Address: 6 Wayne Close Batley wf170eu

Application number: 2020/94210	
What is the application for?:	Erection of extensions and formation of vehicular access (within a Conservation
Address of the site or building:	6, Osborne Terrace, Batley, WF17 0LZ
Postcode:	WF17 5NN

Type of comment: An objection

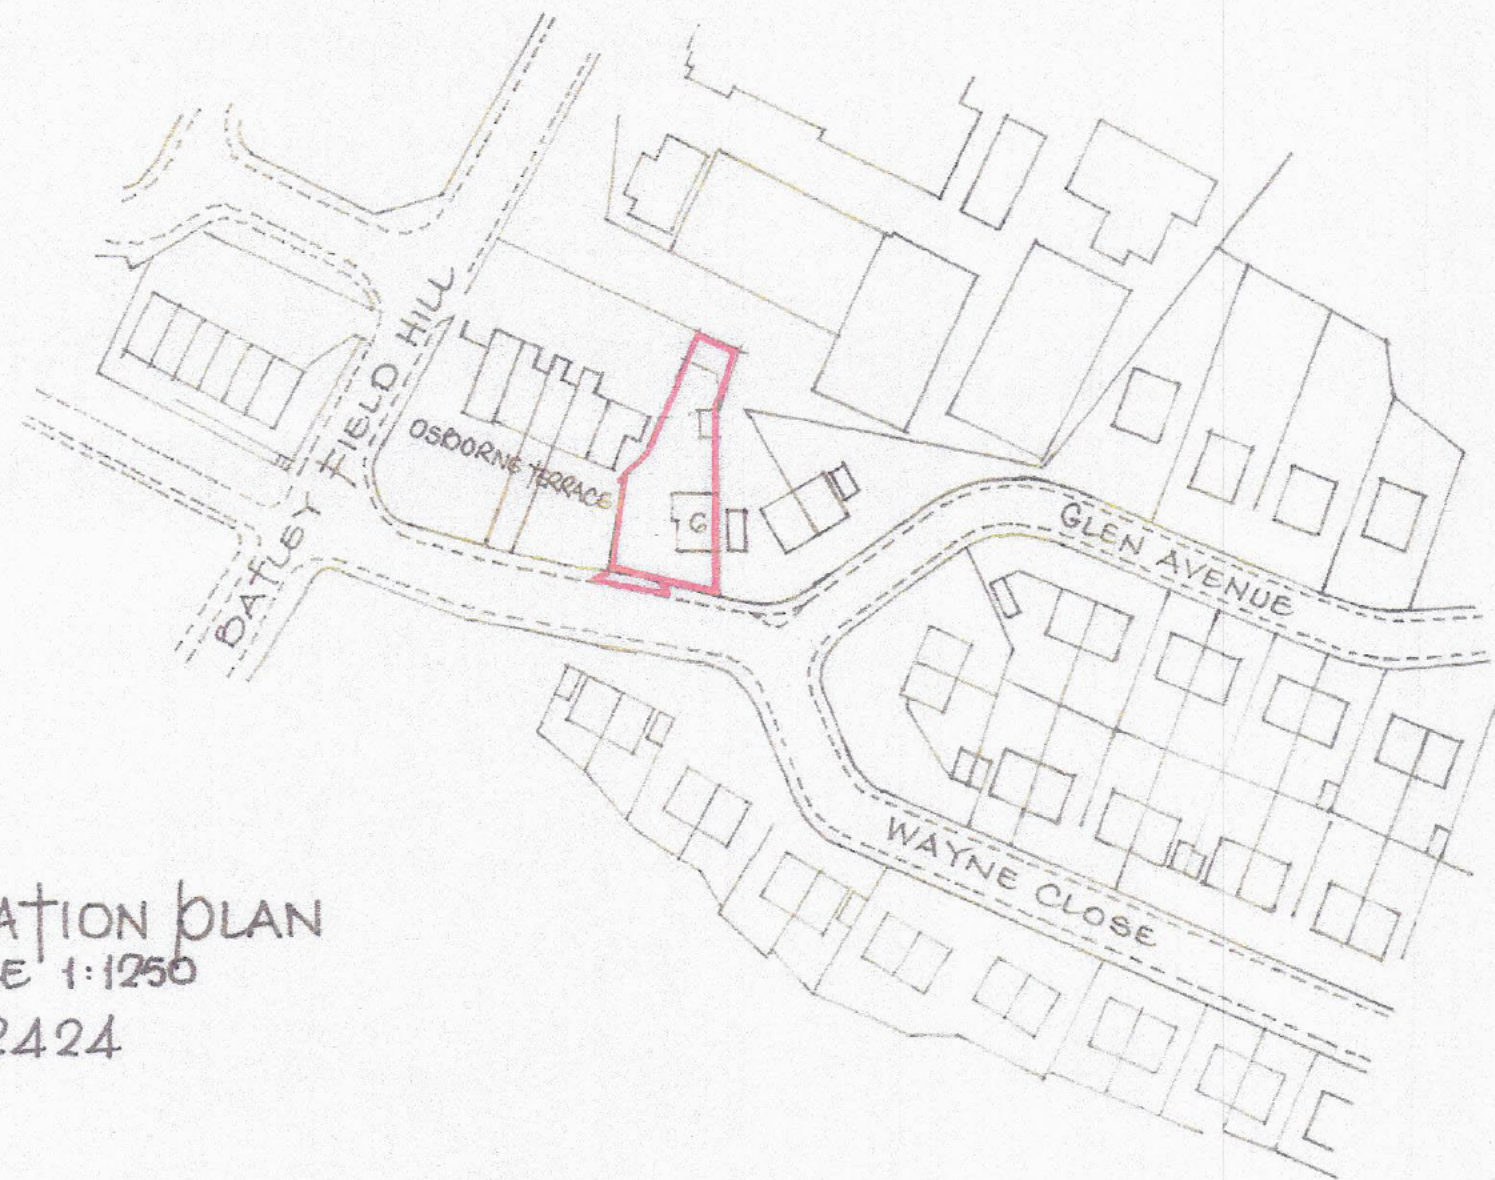
I would like to make in writing my OBJECTION of the vehicle access to the proposed property.

The plans for making vehicle access from Wayne Close should NOT be granted due to the property housed on Osbourne Terrace where the property already has off street parking. The planning originally was granted to the extension without vehicle access from Wayne Close and therefore that must remain the same.

a) residents from Wayne close already use the space on the main road for parking. If vehicle access is granted for 6 Osbourne Terrace it will send precedence for the others on Osborne Terrace to also apply for vehicle access which can create obstruction for emergency vehicles and waste collection services trying to get by due to potential parking on both sides of the road.

b) vehicles racing up and down Glen Avenue therefore creating a blind spot on places such as 6 Osbourne Terrace if they were reversing out onto Wayne Close should permission be granted.

c) during school days it is already very busy with parents parking on both sides of the street on Wayne Close while they are waiting for their children to finish from Batley Boys School. When cars are parked on both sides of the street or vehicles reversing from both sides of Wayne Close can potentially create a blind spot or hazard for children crossing or waiting for their parents.

Kirklees must take into consideration that the property already has vehicle access from Osbourne Terrace and should advise the applicants that they must continue to use their already existing vehicle access from Osbourne terrace.
